COMMUNITY DEVELOPMENT DEPARTMENT
501 Delta Avenue ♦ Marysville, WA 98270 ♦ (360) 363-8000

Re: M-51 Industrial – *Technical Review 2*
PA 23014

A PORTION OF THE NW 1/4, SW 1/4, SEC 27, TWN 31 N, RGE 5 E, W.M. CITY OF MARYSVILLE, SNOHOMISH COUNTY, WASHINGTON

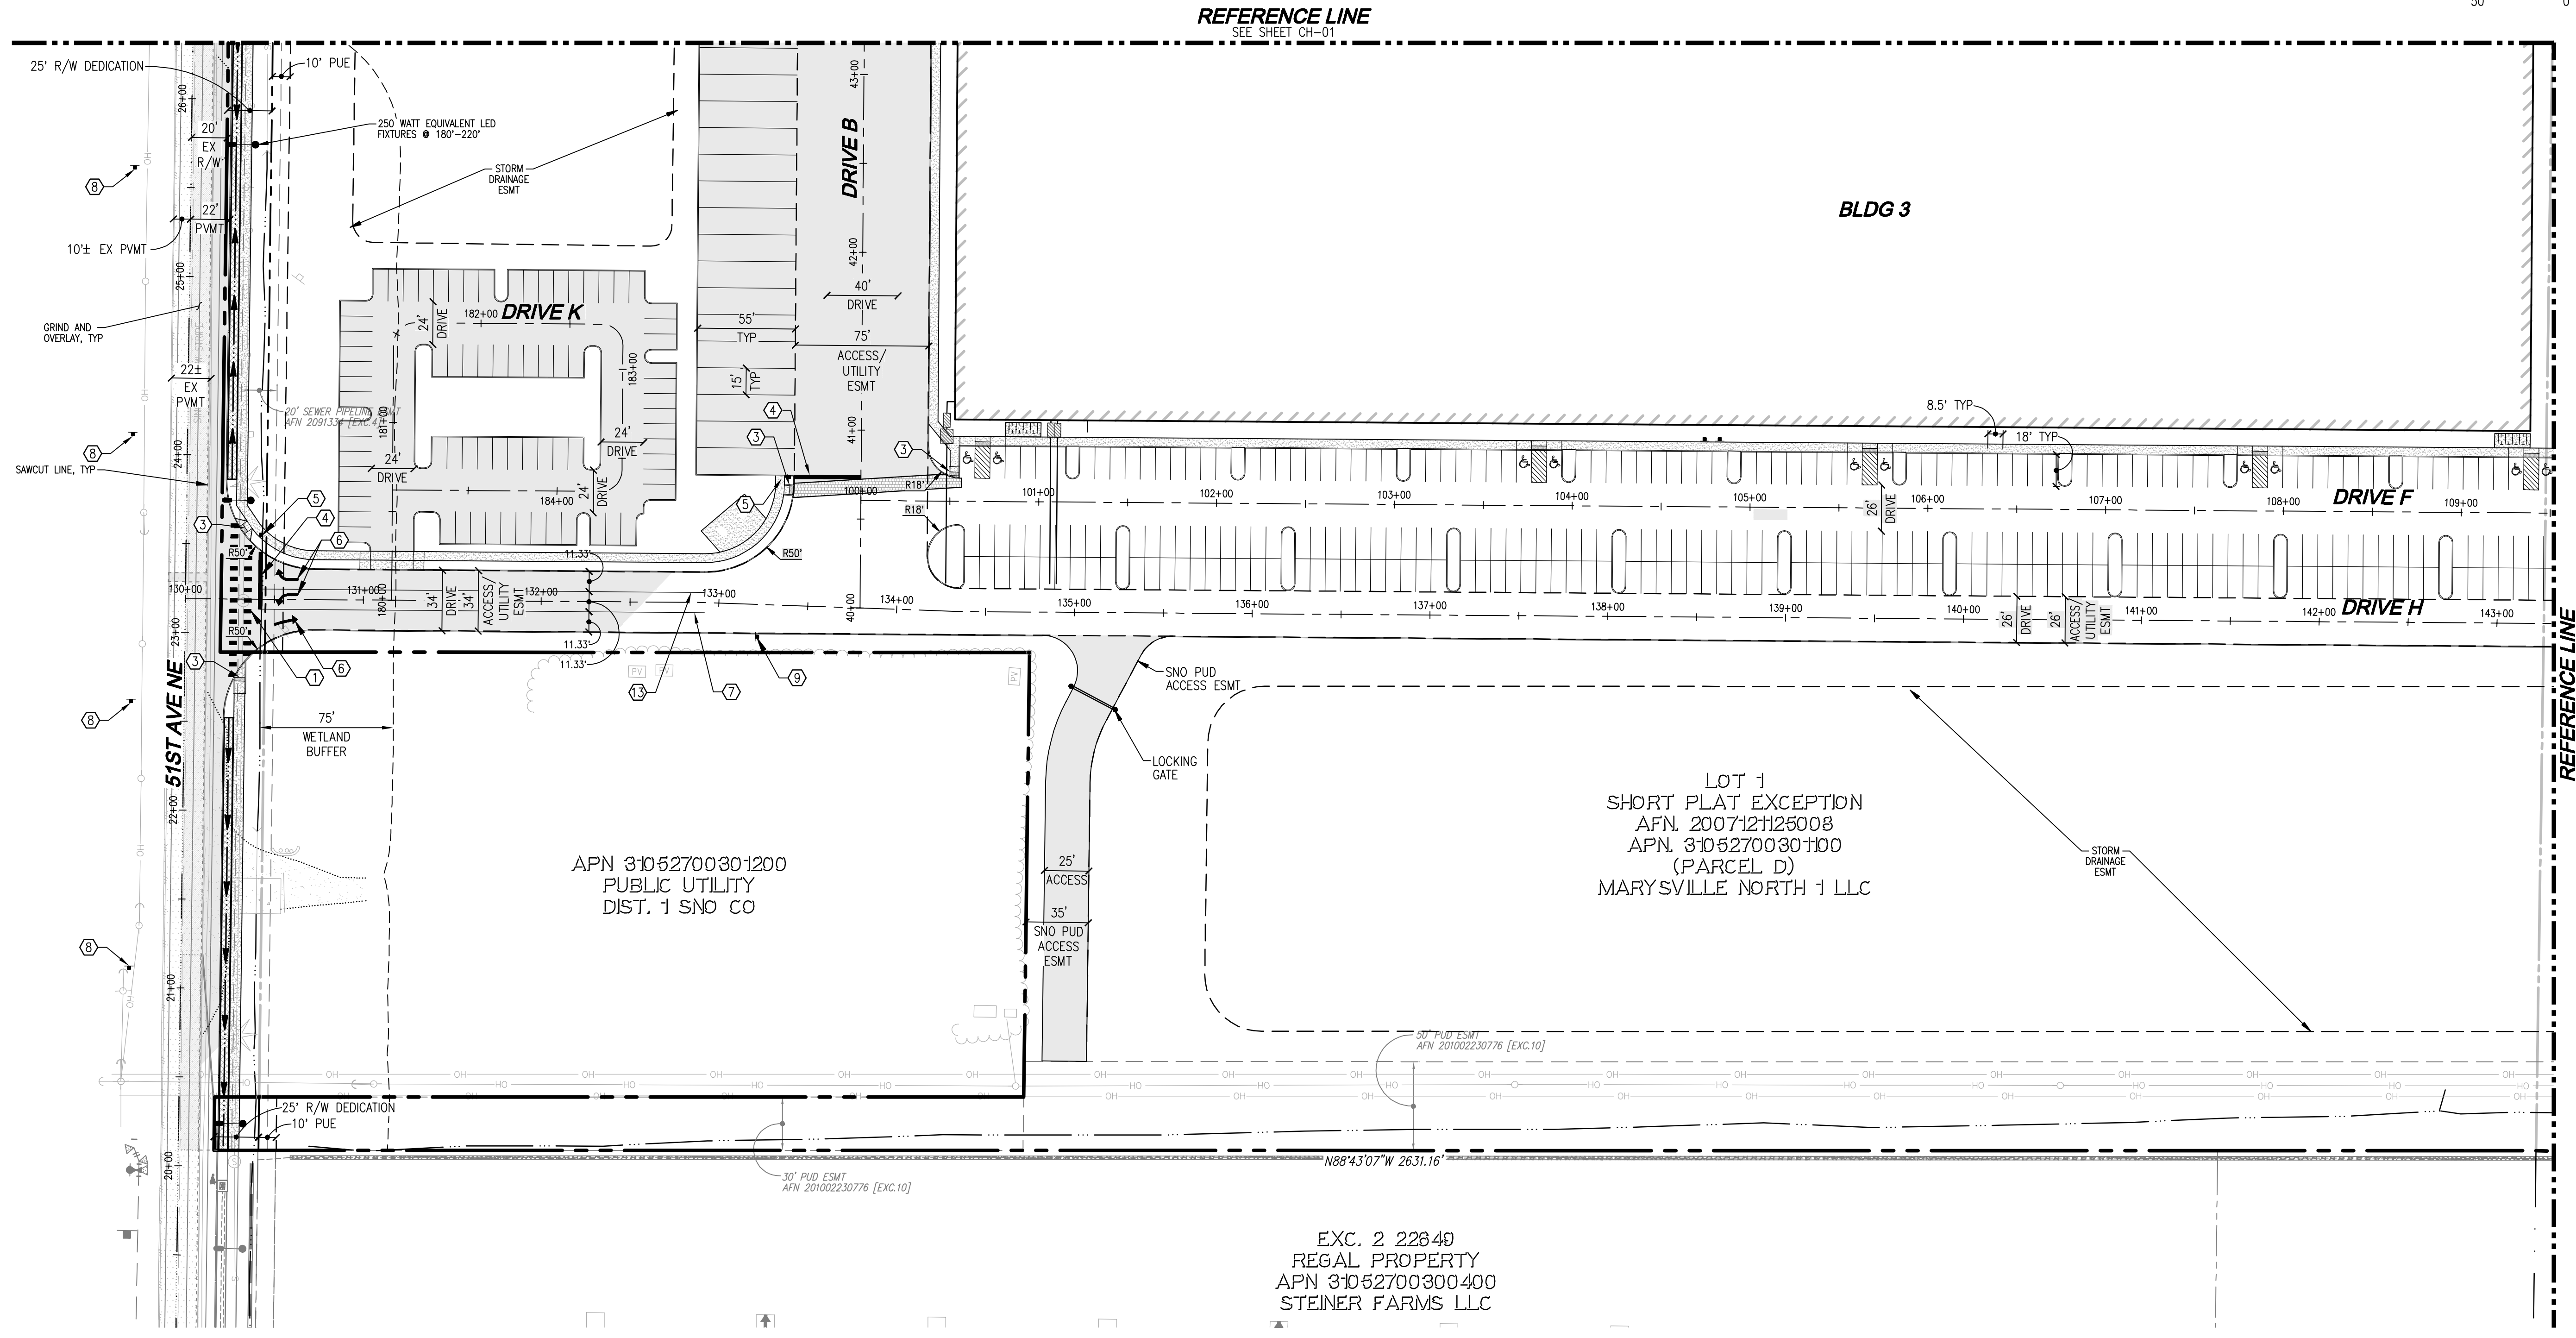
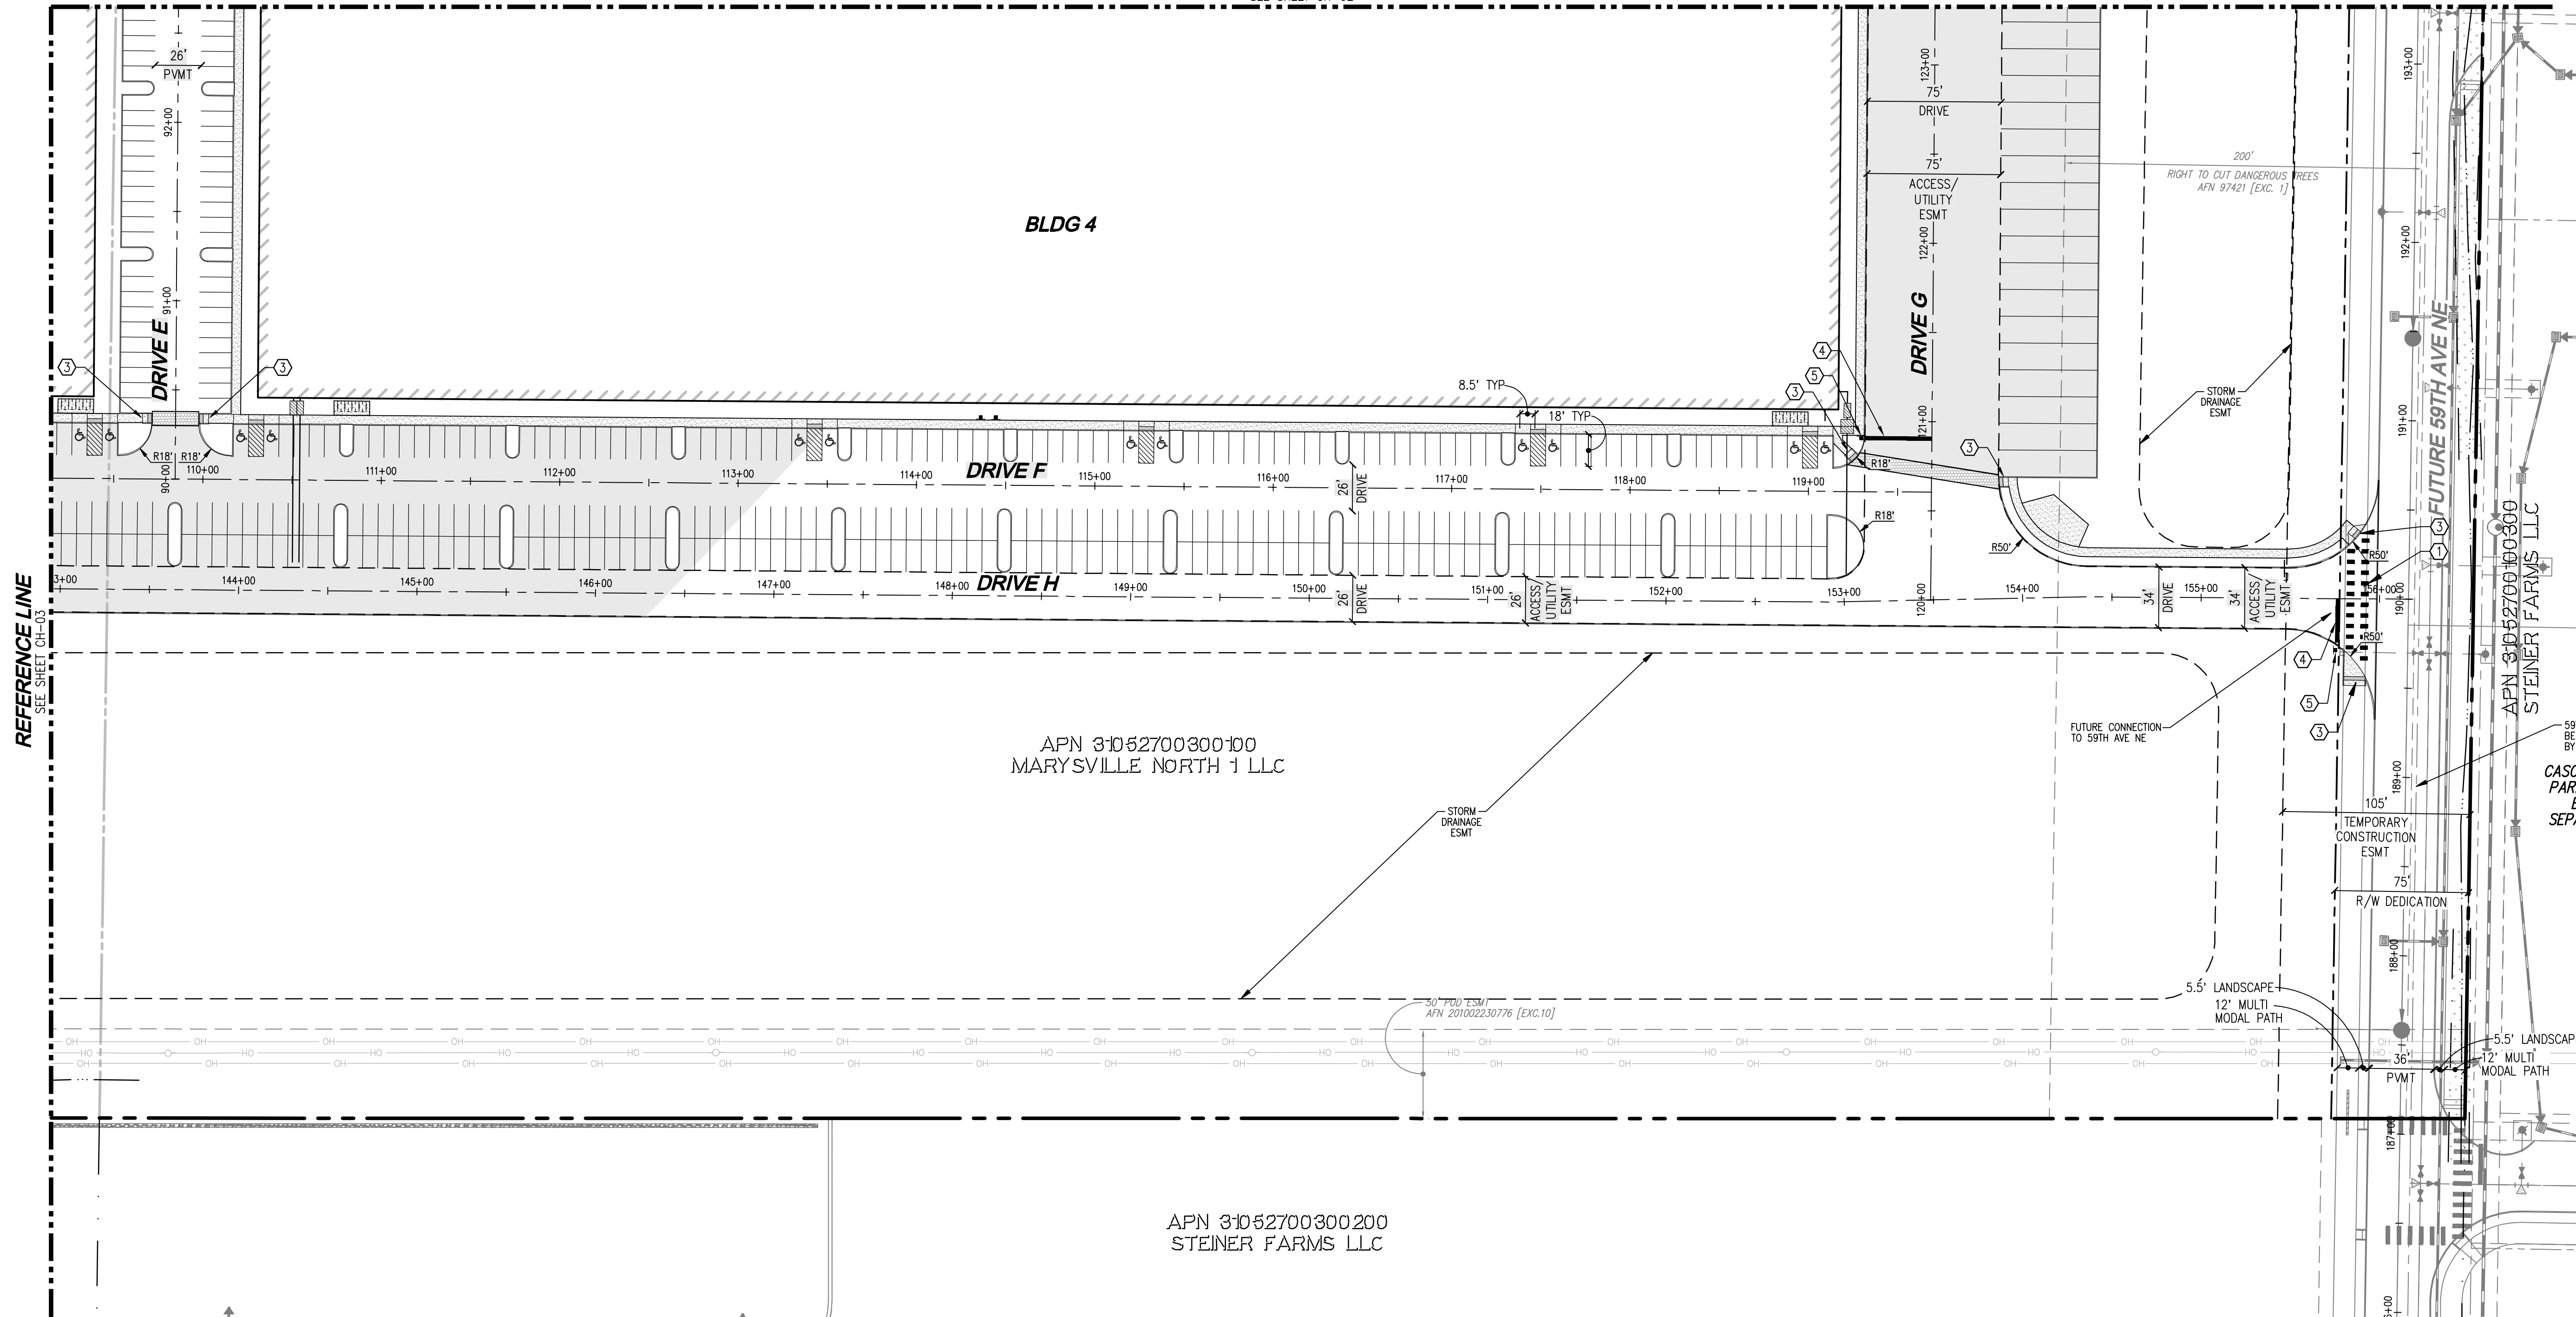
23. Conceptual street lighting shown on 51st Ave NE on combined utility sheet is highly inconsistent compared to previously provided typical spacing. No conceptual street lighting is shown on 59th Ave NE but will be required. This is acceptable for planning approval but shall be finalized during construction plan review.

- a. Street lighting shall be designed as minor arterial utilizing 250 watt equivalent LED fixtures.
 - b. Spacing of fixtures should be approximately 180'-220'.
